PLAN REVIEW SHEET

Petition #: RZP 2020-007

Address: 10720 Woodland Beaver Road

Request: B-1 (CD) to B-1 (CD) SPA

SITE PLAN AMENDMENT
TECHNICAL DATA SHEET

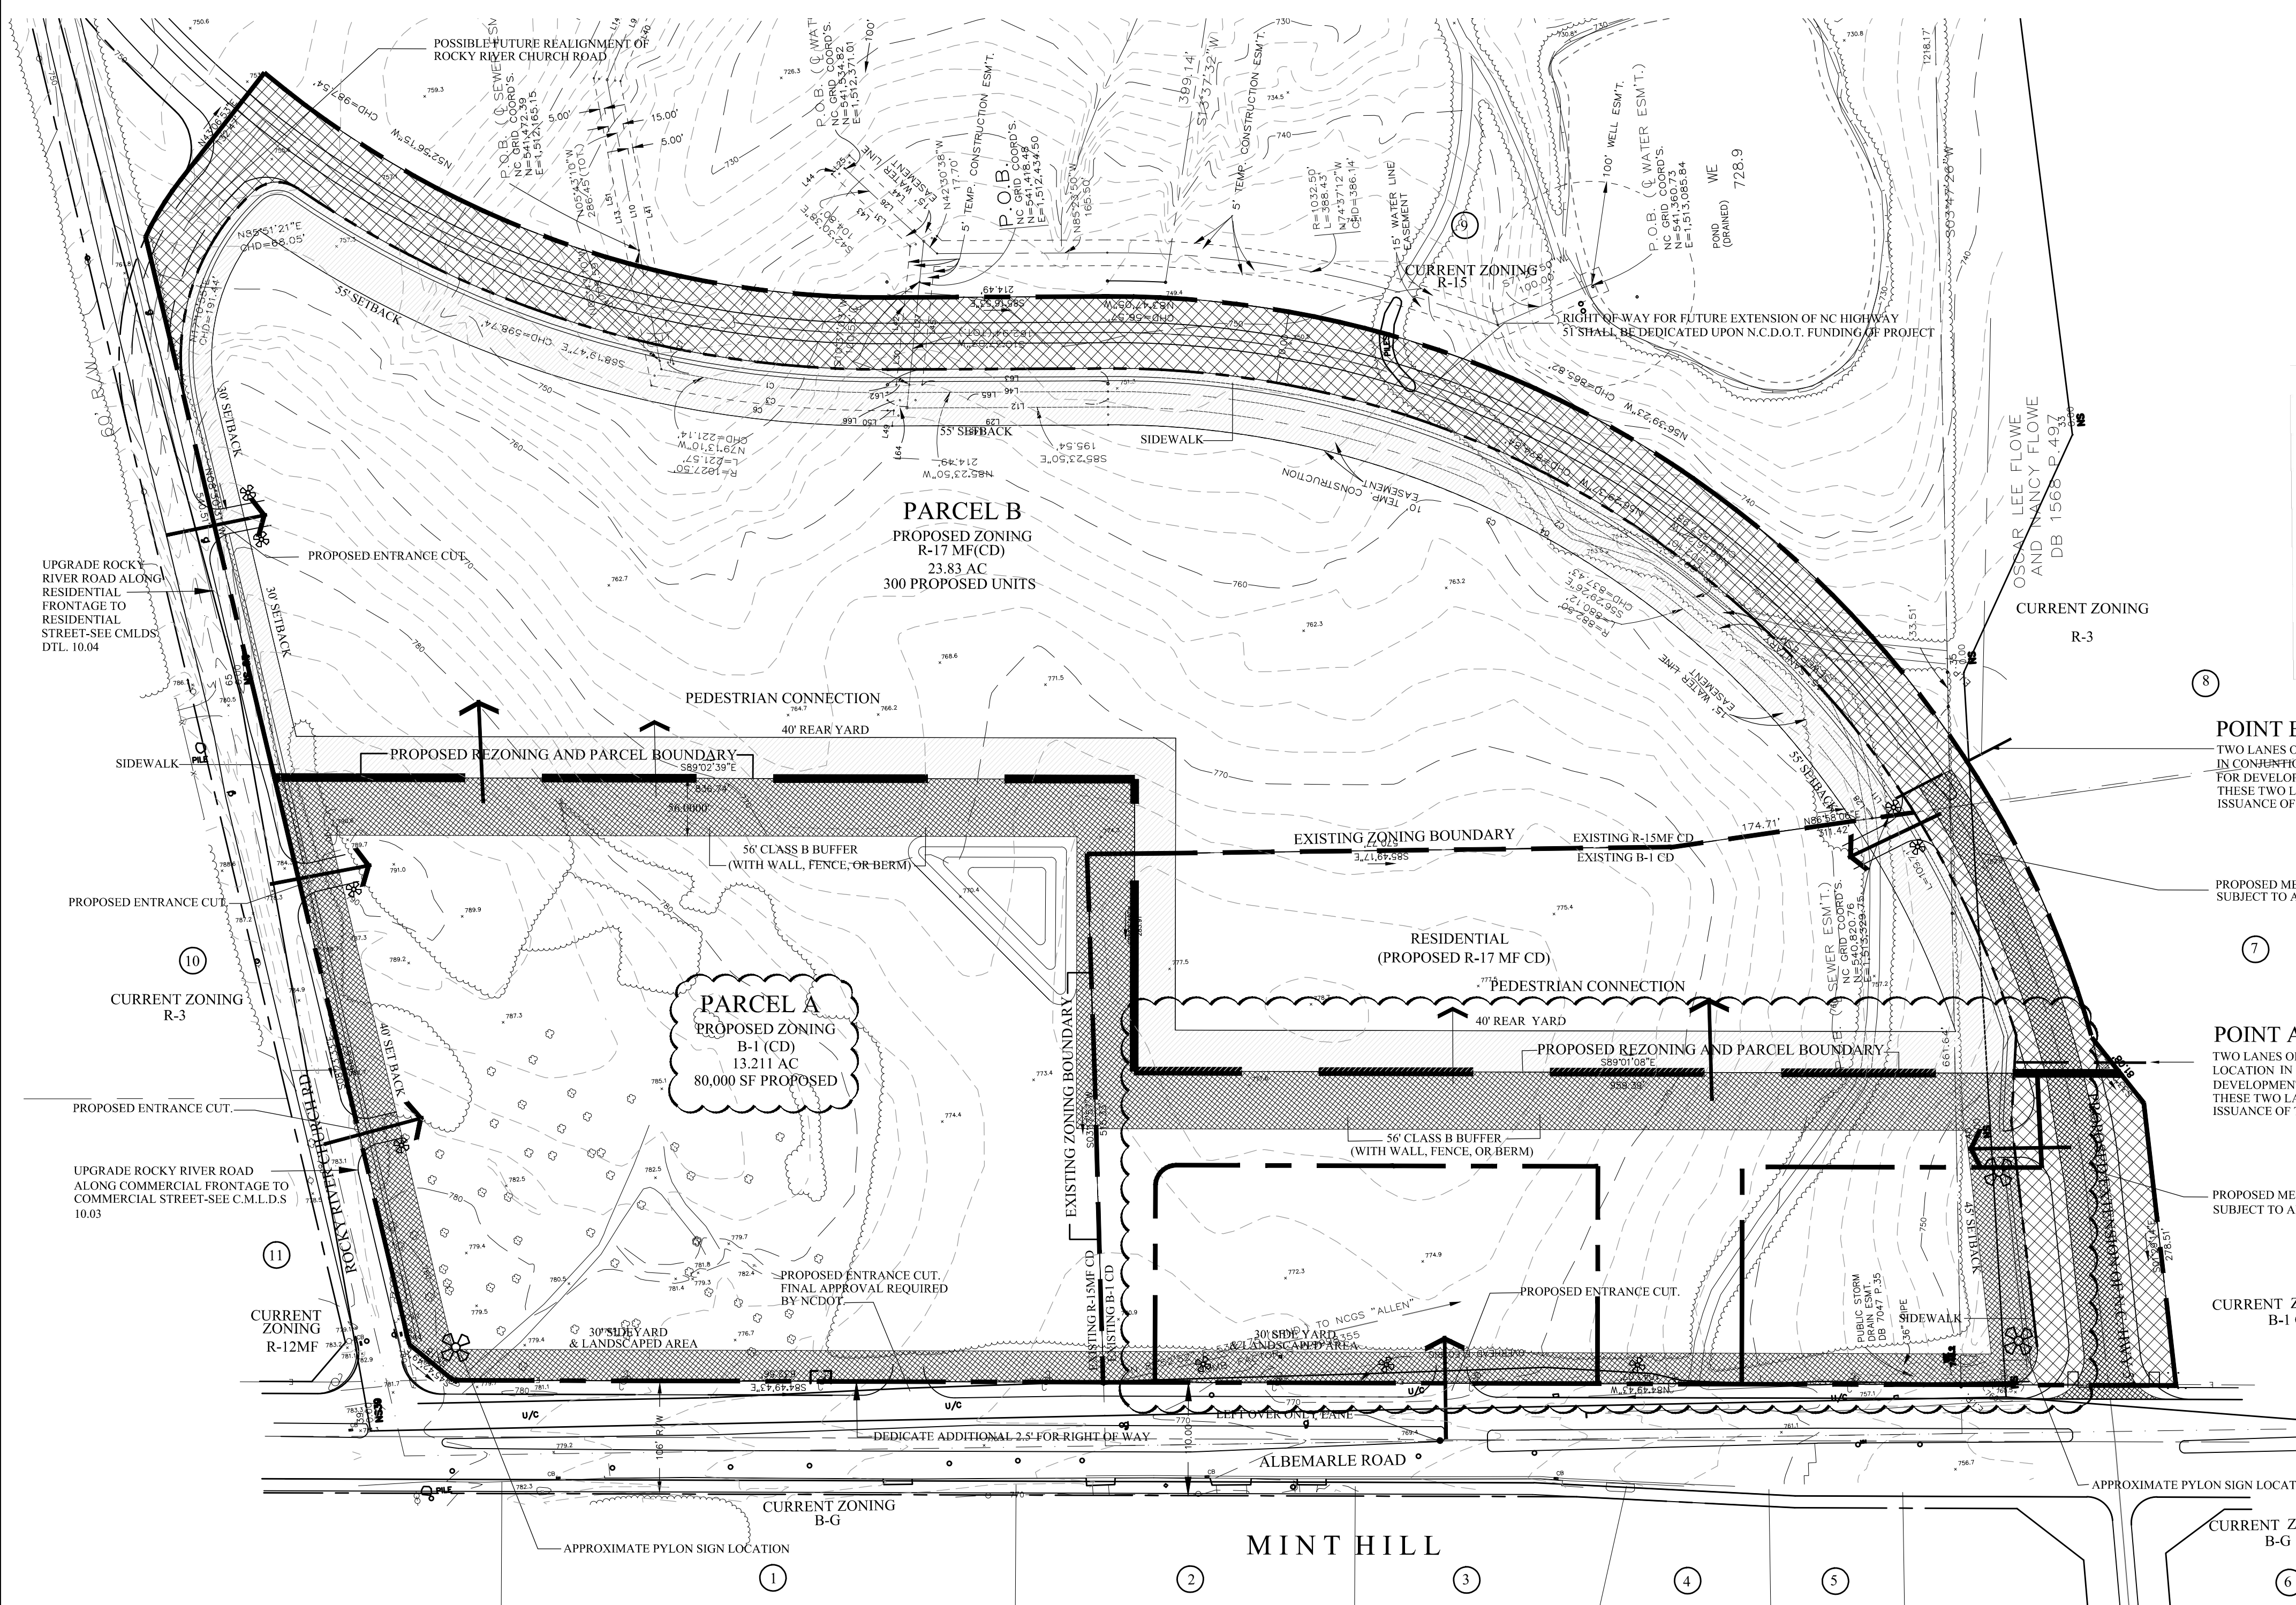
CATS does not have an existing route in this location but there are plans to extend a local route along Albemarle Road to the Novant Health facility and north to Blair Road. CATS requests the petitioner to install an ADA compliant bus waiting pad per land development standard 60.01B. The exact location will be determined during the permitting process.
